14 August 2019

Our Reference: SYD18/00502/03 (A28698917)
Department Ref: SSD 9210

**RESPONSE TO SUBMISSION FOR PROPOSED SAINTS PETER AND PAUL ASSYRIAN
PRIMARY SCHOOL AT 17-19 KOSOVICH PLACE, CECIL PARK**

FIGURE 2: EXISTING INTERSECTION LAYOUT

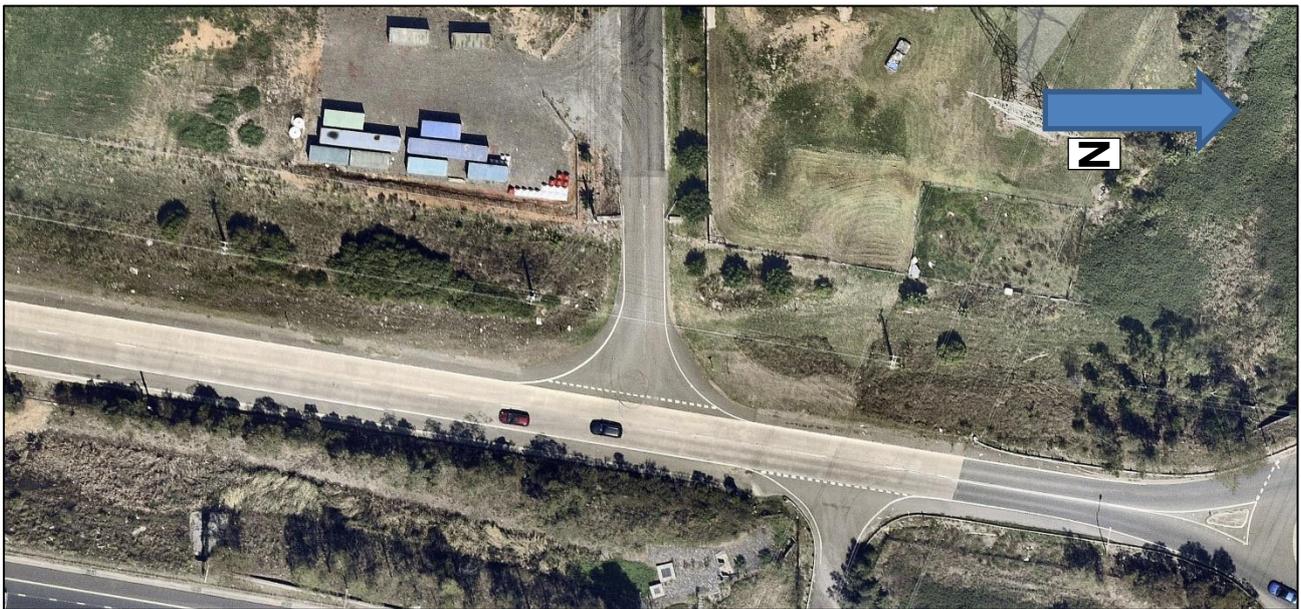
Roads and Maritime has reviewed the submitted information and does not support the proposed CHR (channelized right turn bay) treatment on Wallgrove Road at Kosovich Place intersection based on road safety and network efficiency grounds. The proposal would be a potential safety hazard for right turning traffic as motorists have to wait for a safe gap which could frustrate the drivers due to the high through traffic volume.

Based on the above and considering safety for the school children Roads and Maritime requires provision of a roundabout at the intersection of Kosovich Place and Wallgrove Road. A roundabout at this location will improve safety for turning traffic and also will reduce the approach speed at the subject intersection.

The roundabout shall be designed to meet Roads and Maritime requirements, and endorsed by a suitably qualified practitioner. The design requirements shall be in accordance with AUSTRROADS and other Australian Codes of Practice. The certified copies of the civil design plans including swept path diagrams shall be submitted to Roads and Maritime for review.
